Wednesday 20 September 2017

Our Ref CRTR-PLAN-2017-
23185

Proposal: Erection of 70 (over 55) retirement apartments comprising of four blocks, provision of a community building, electricity substation and laying out of internal roads, parking areas and greenspace and associated infrastructure

Location: Lidl, Station road, Mirfield

CLIENT: DARREN SMITH HOMES	DRAWING NUMBER: P16:4981:04
PROJECT: FORMER LIDL SITE STATION ROAD, MIRFIELD	SCALE @ A1: 1:200
DRAWING: SITE SECTIONS	DRAWN: SD DATE: AUG 17
	CHECKED: KM/MLM DATE: AUG 17

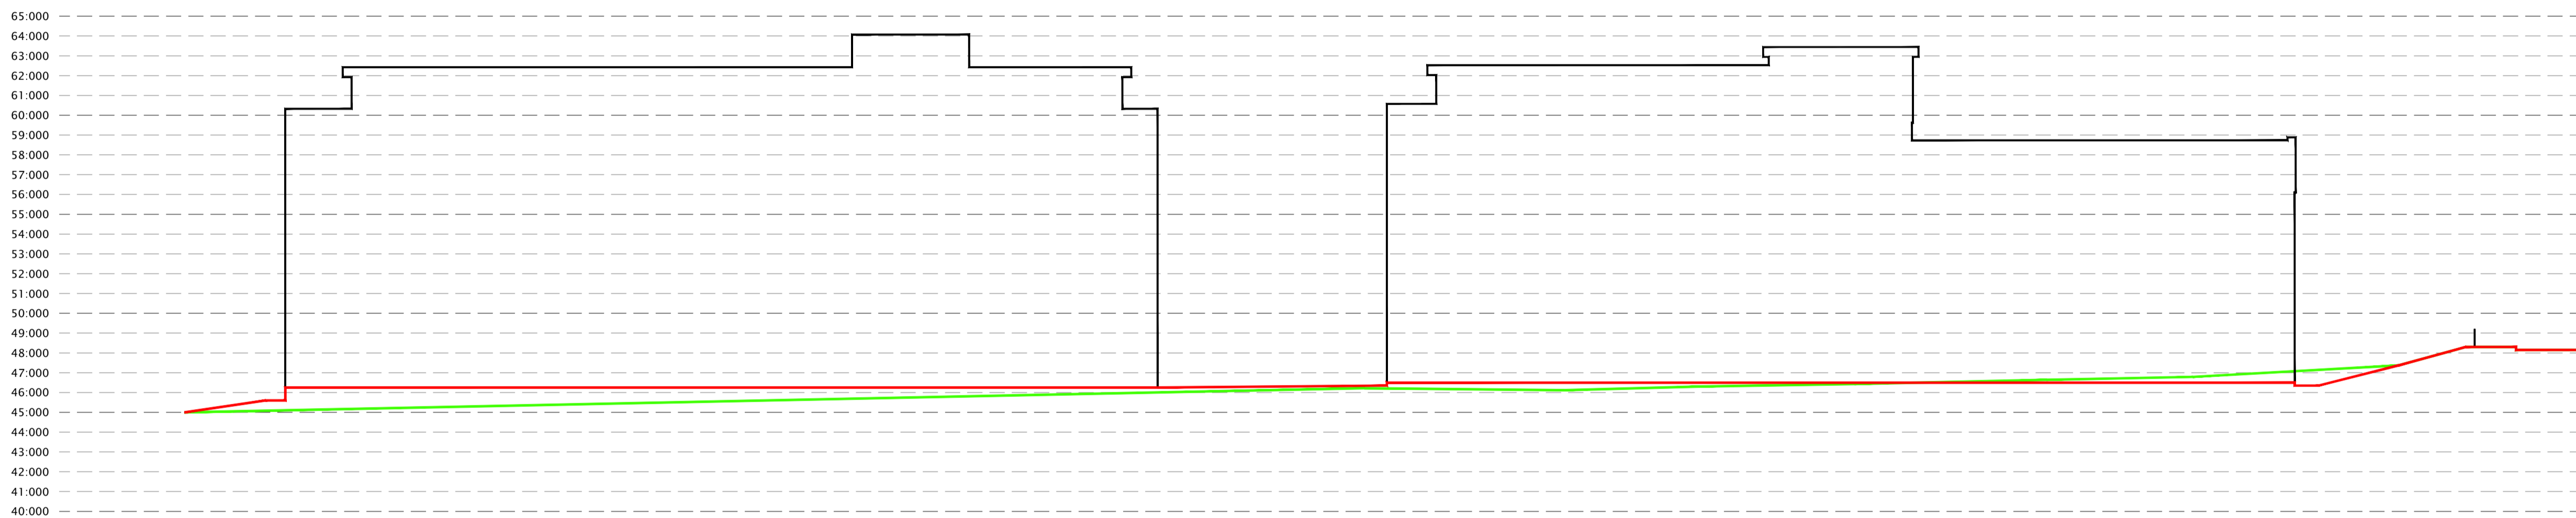
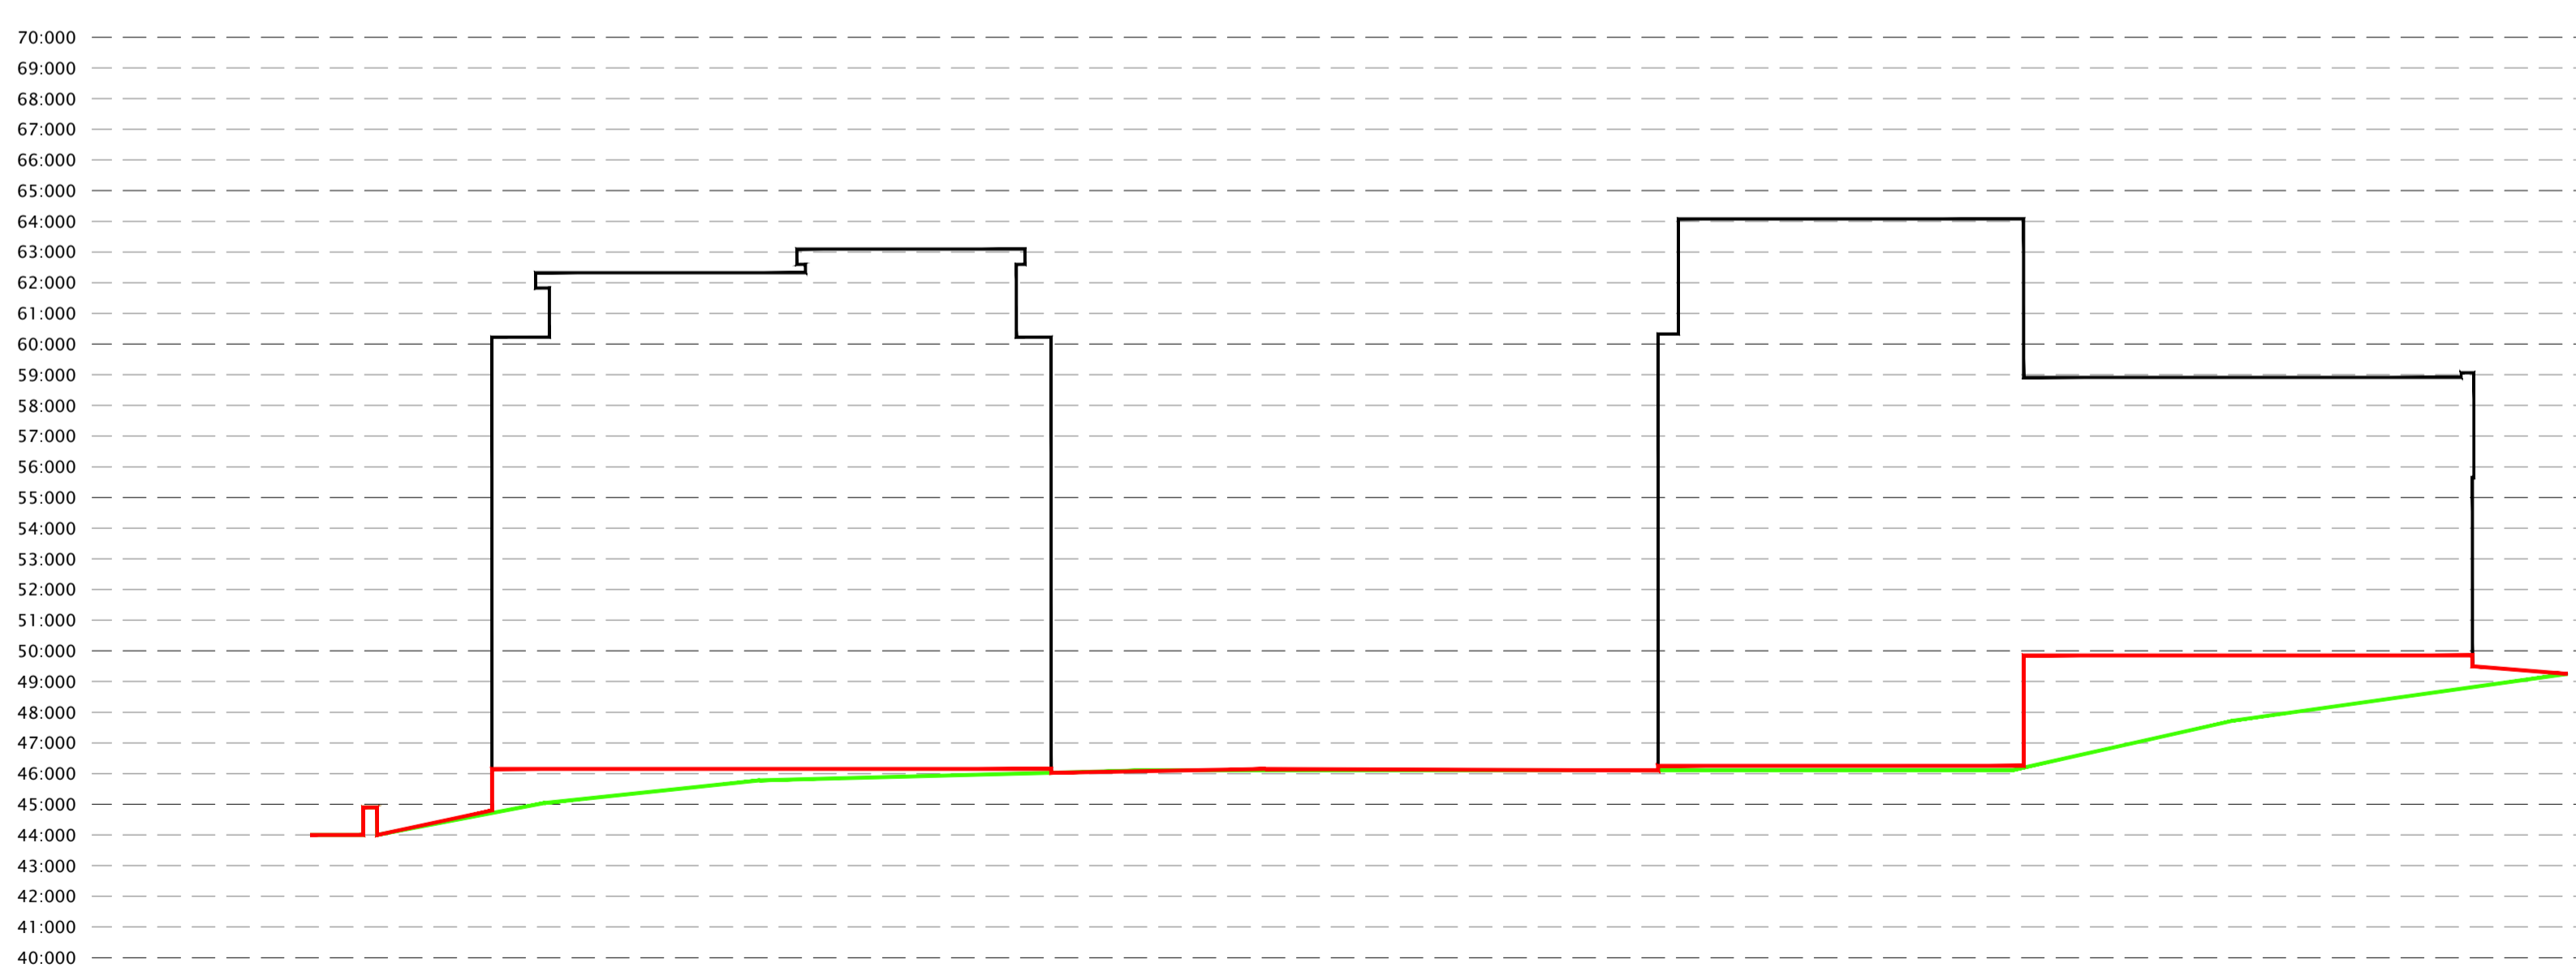
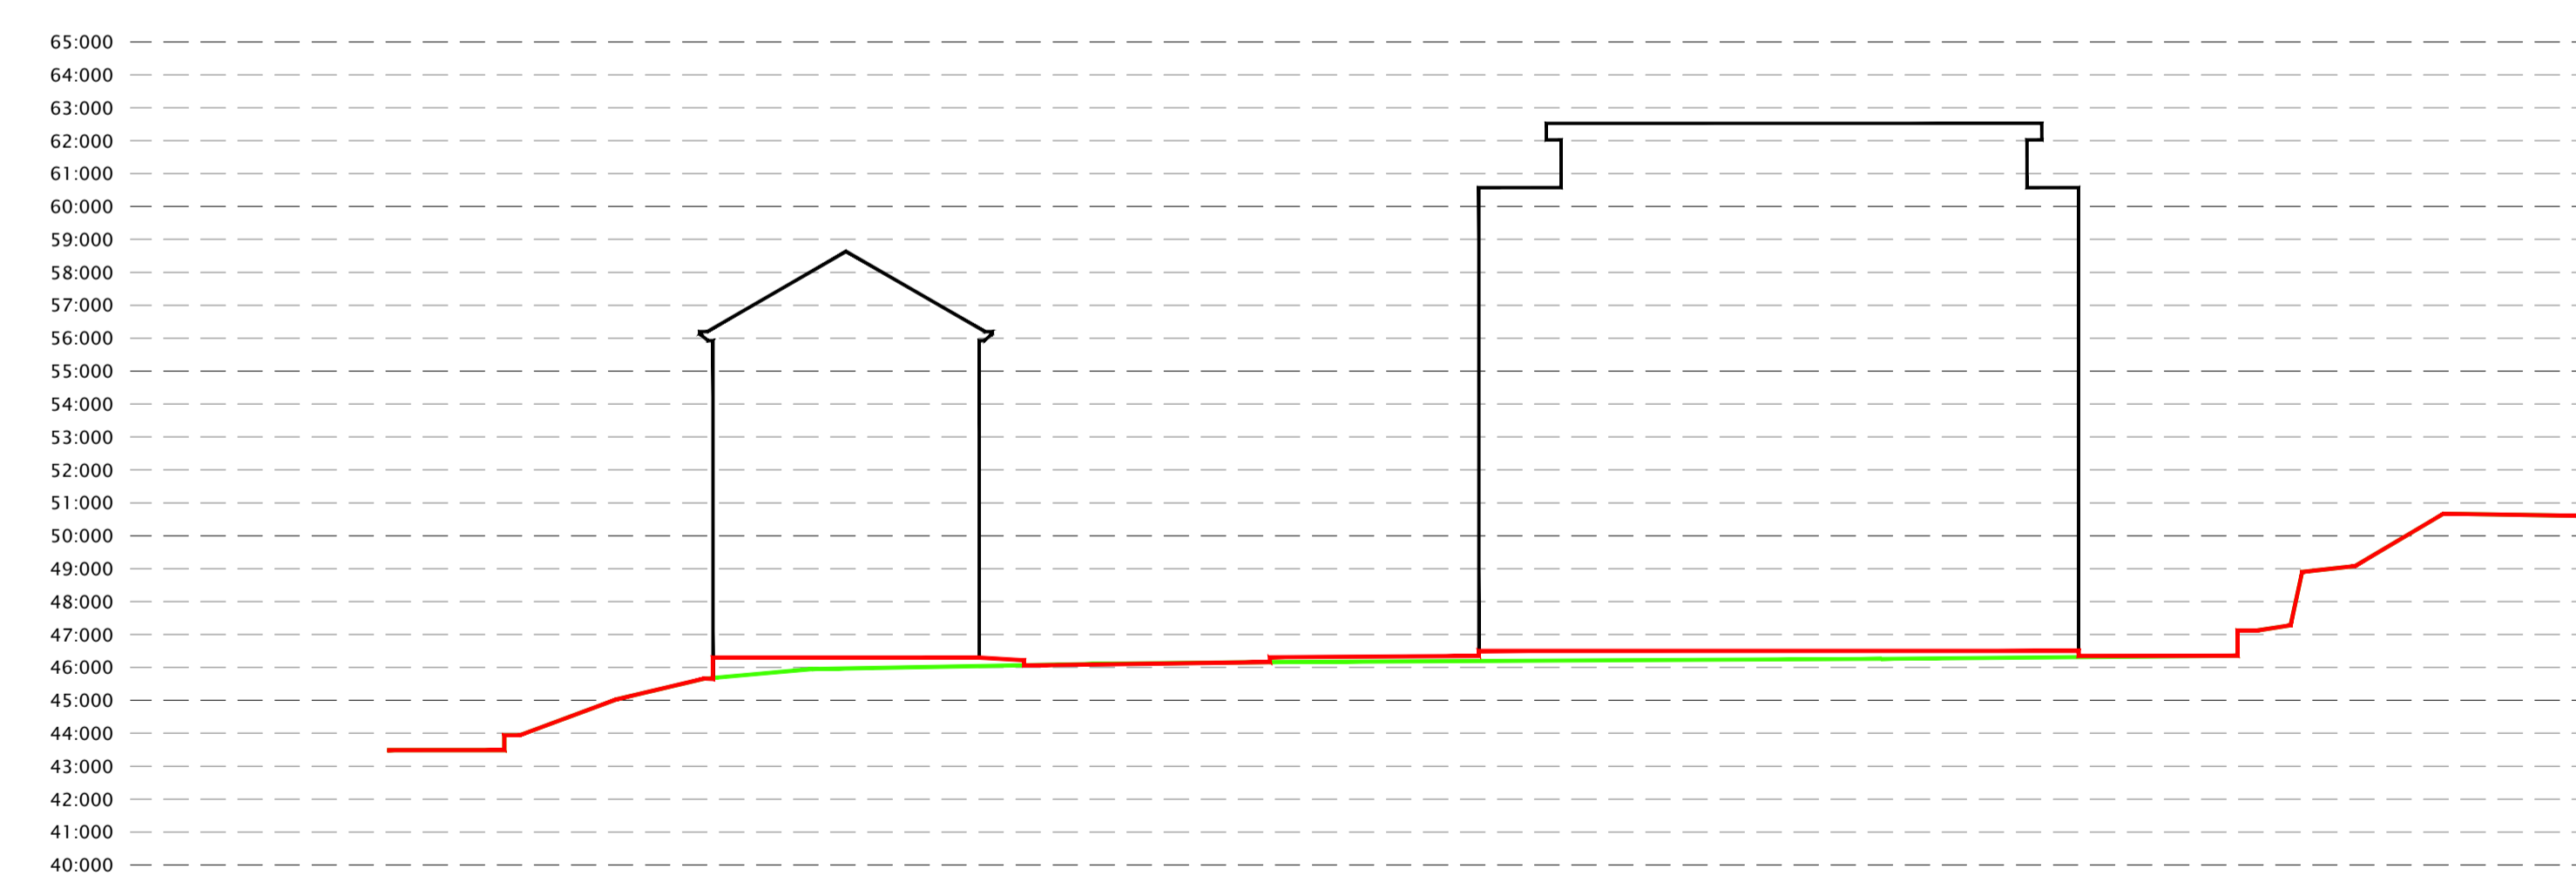
The proposed building works will be situated within proximity to the canal, and will include new retaining walls to deal with the land levels on site.

The developer will need to demonstrate that any temporary or permanent works associated with the proposed development will not impose any additional load onto the canal wash wall and that foundations provide support to his development without

any negative impact on the Trust's assets, such as the towpath, walls, or the canal itself.

We therefore request that any consent includes pre-commencement conditions that require the submission of foundation details, including cross sectional drawings showing their relationship relative to the canal.

BLOCK B  
FFL: 45.100  
CANAL ELEVATION A-A

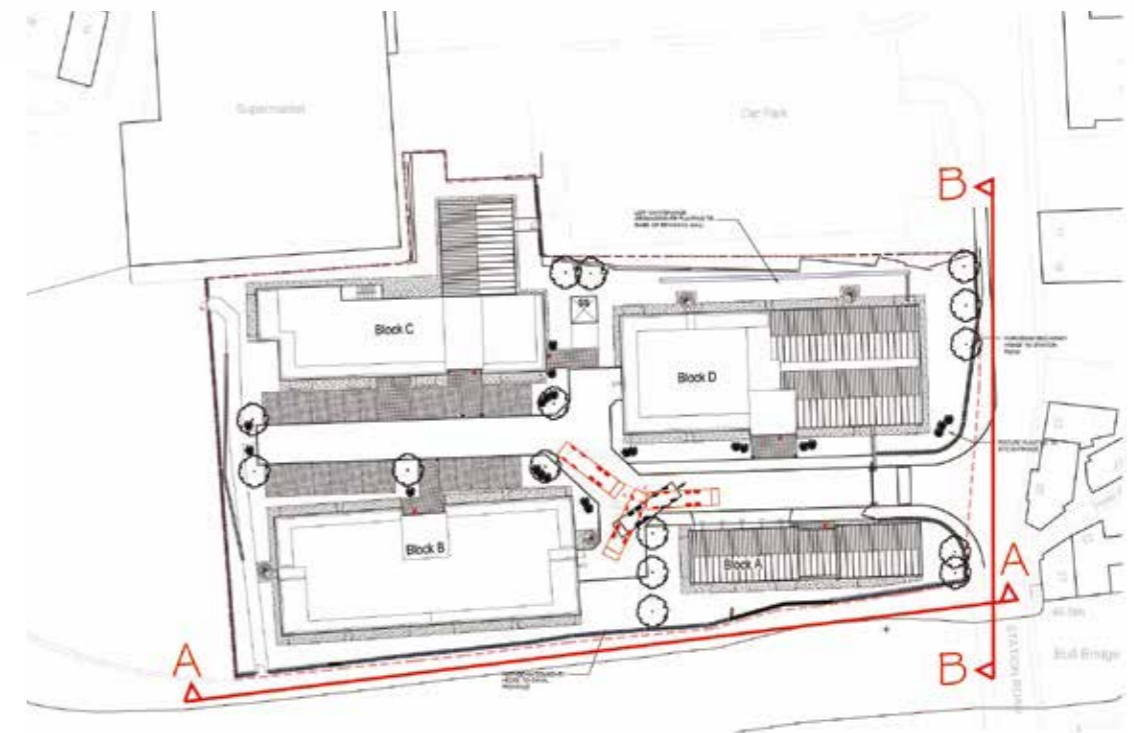
Proposed block 'B' is sited approximately 5m from the southern curtilage of the site, and 12m distant from boats moored to the south. The proposed block is 5-stories in height, and features main living windows and external balconies facing the canal. It is considered that the combination of height, proximity, and the presence of external balconies could result in a significant erosion of privacy for users of the existing moorings. The impact would be more significant than that from the neighbouring development to the west, where the approved building is not as tall and features a reduced number of balconies. The impact on the privacy of nearby residents does need to be considered in line with the aims of policy BE12 from the saved Kirklees Local Plan, which requires the need for design to ensure that no detriment will be caused to existing occupiers of adjacent premises.

We therefore request that amendments are made to the scheme to reduce the perception of overlooking towards residential boats to the south. Measures could include the reduction to balcony numbers, the setting back of the building further from the canal (which could also reduce the potential for apartment residents to suffer from noise or odour nuisance from boaters), a reduction in height, and the inclusion of louvre screening to the remaining balconies.

In addition to the above, we do note that the ground floor of the block 'B' will be visible from the canal. The narrow openings to the parking area of the block risk making the immediate ground floor appear overbearing to the neighbouring towpath. We therefore would request that consideration is given to widening the openings shown so that they mirror the width of the openings above, which would improve the appearance of this elevation. This would also mirror the arrangement approved for the parking areas upon the development to the west of the site.
